Planning Application Ref: BR/208/17/DOC (BR/270/16/PL)

Location: Villa Maria, Campbell Road, Bognor Regis

Description of works: Discharge of Condition 4 is sought – Tree Protection Issues

Project:-			
Proposed Conversion Villa Maria Campbell Road Bognor Regis			
Title:-			
Proposed Tree Works			
Client:-			
SCG Properties Ltd			
Scale:-			
1:100 (@A1)			
Drawn By:-		Checked By:-	
PJD			
Date:-		Date:-	
18/07/17			
Job.No:-		Rev:-	
160035		24

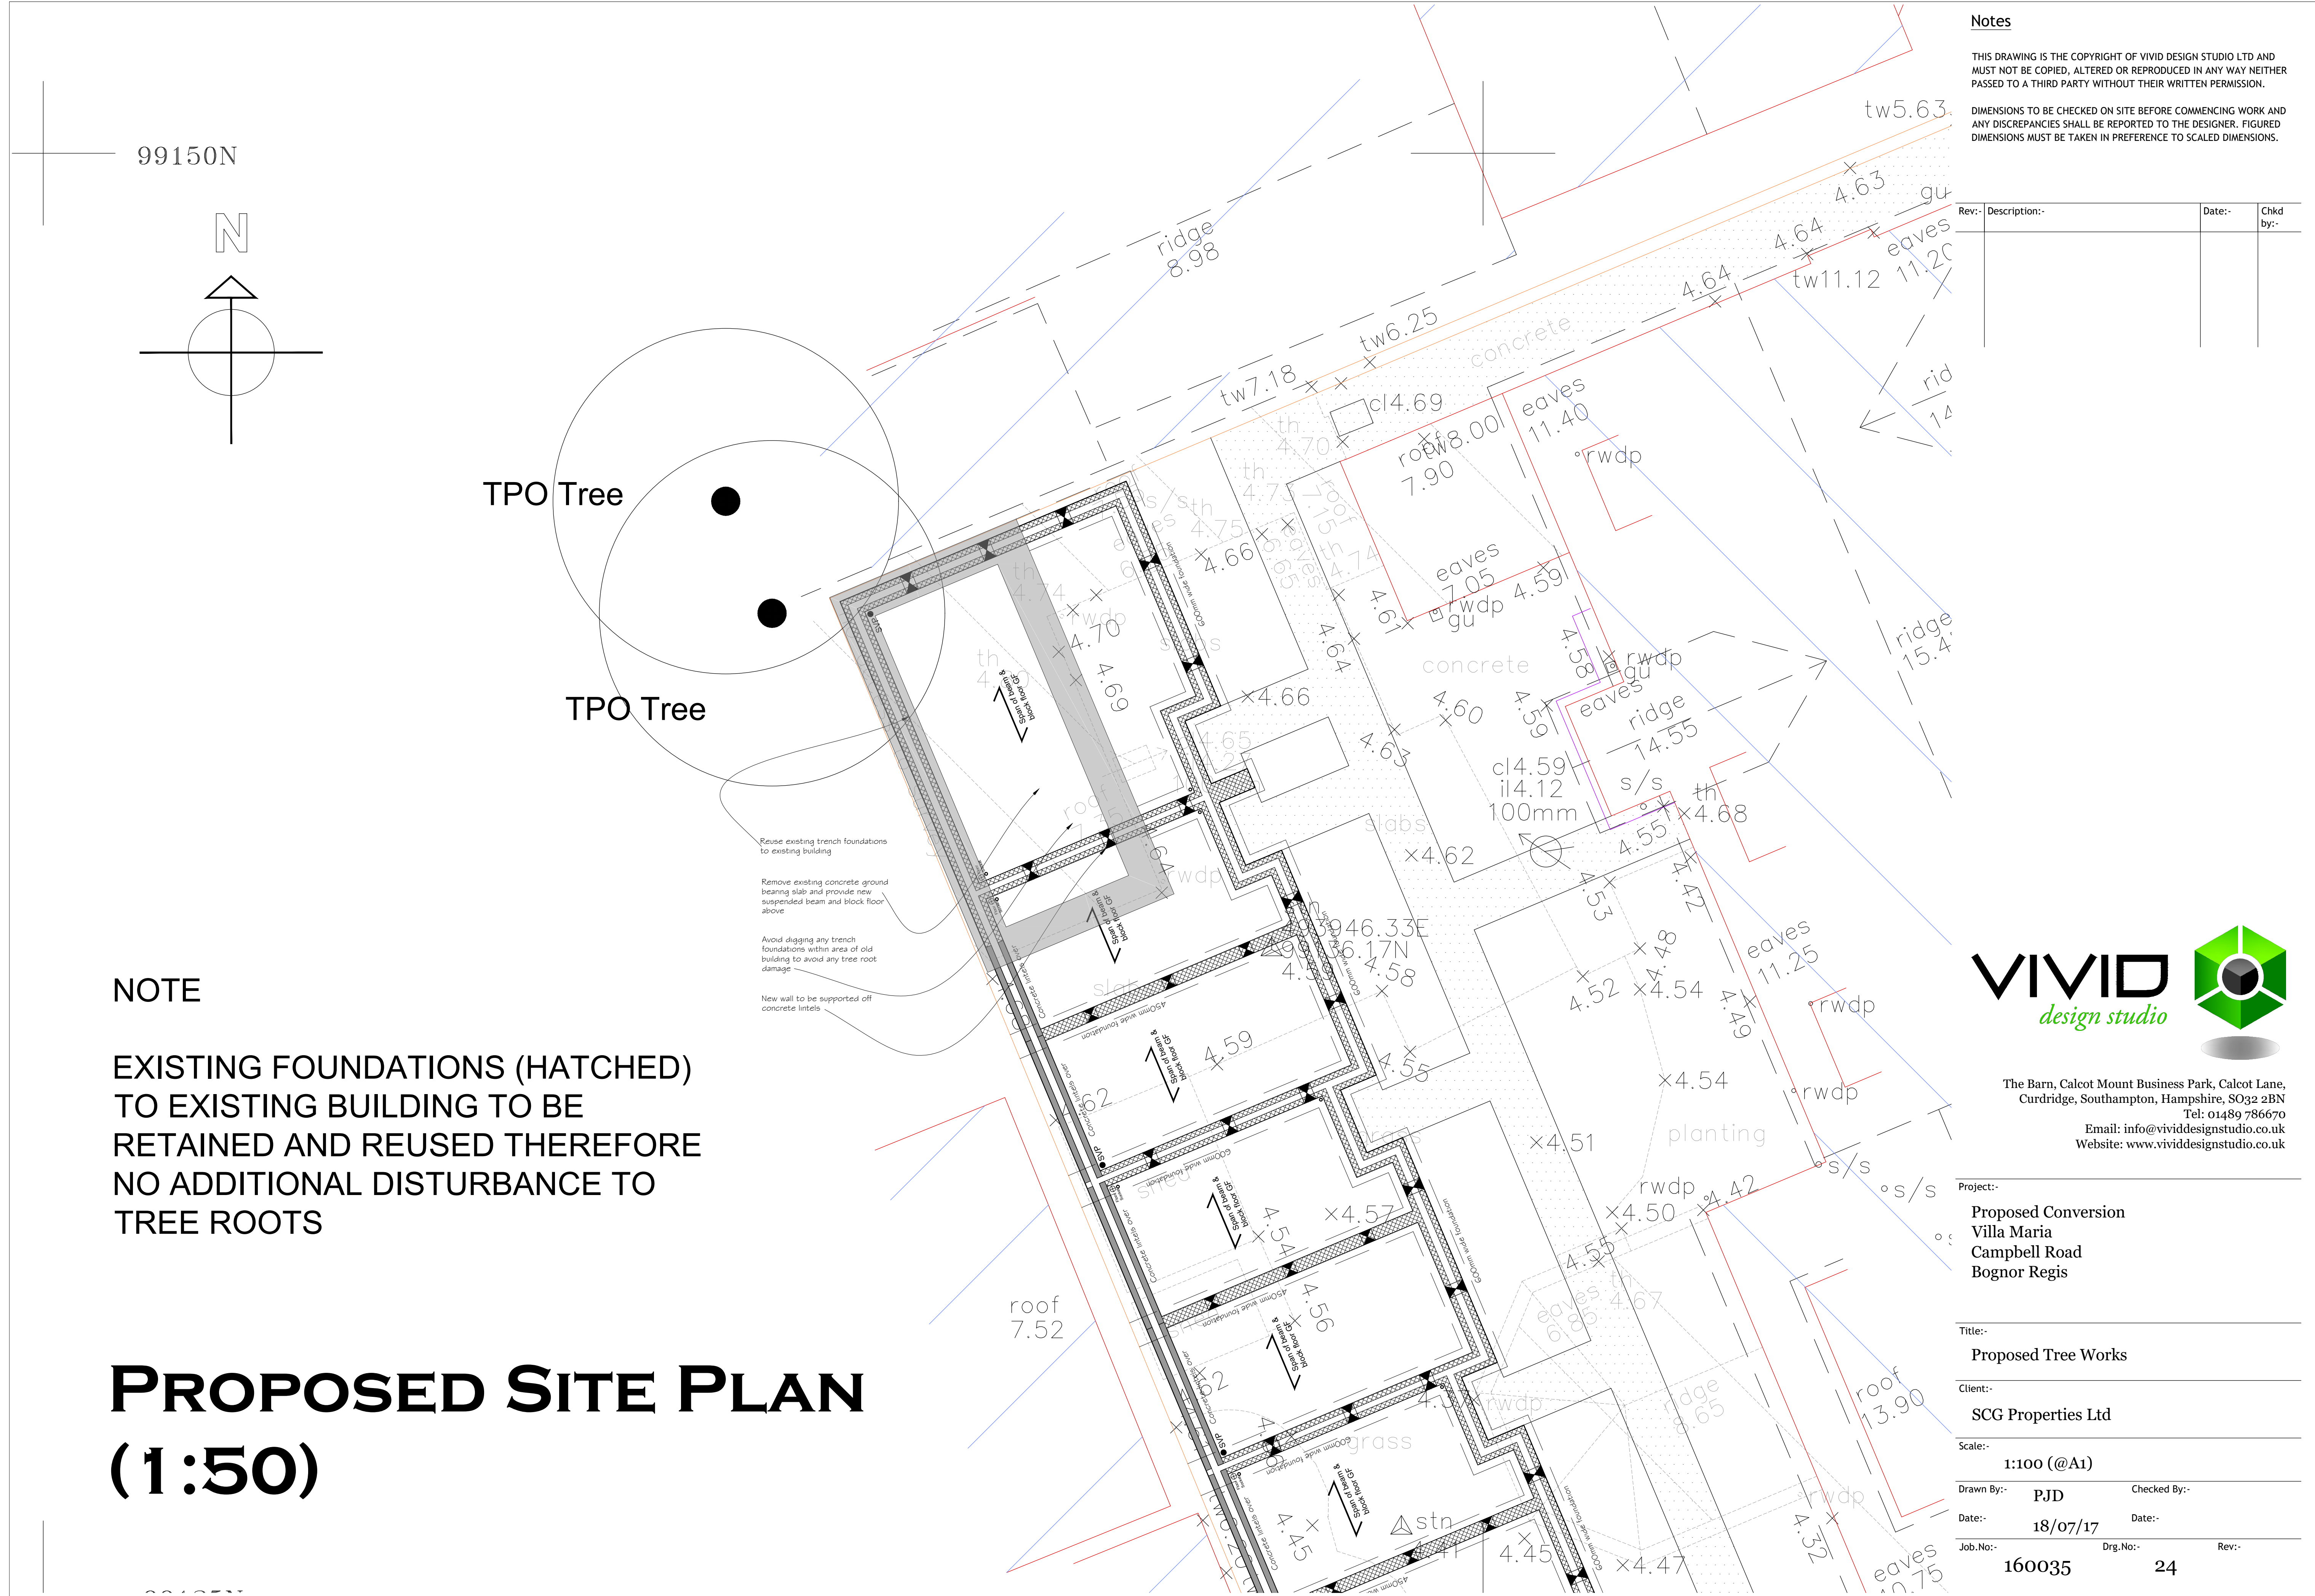
- The Proposed Site Plan received from VIVID design studio states that the existing foundations will be retained to protect tree roots - but I note that it also bears an annotation that the ground bearing floor slab will be removed and replaced - thus roots could be exposed and damaged in the process.

- In order for me to be able to sign off on this Condition I will need to see a mini method statement report submitted from a Consultant Tree Expert stating how this will be carried out without damaging any tree roots + details of their intentions to be there when the slab is removed to satisfy the monitoring & supervision aspect of this Condition + a written report submitted with photographs to show that no harm came to tree roots.
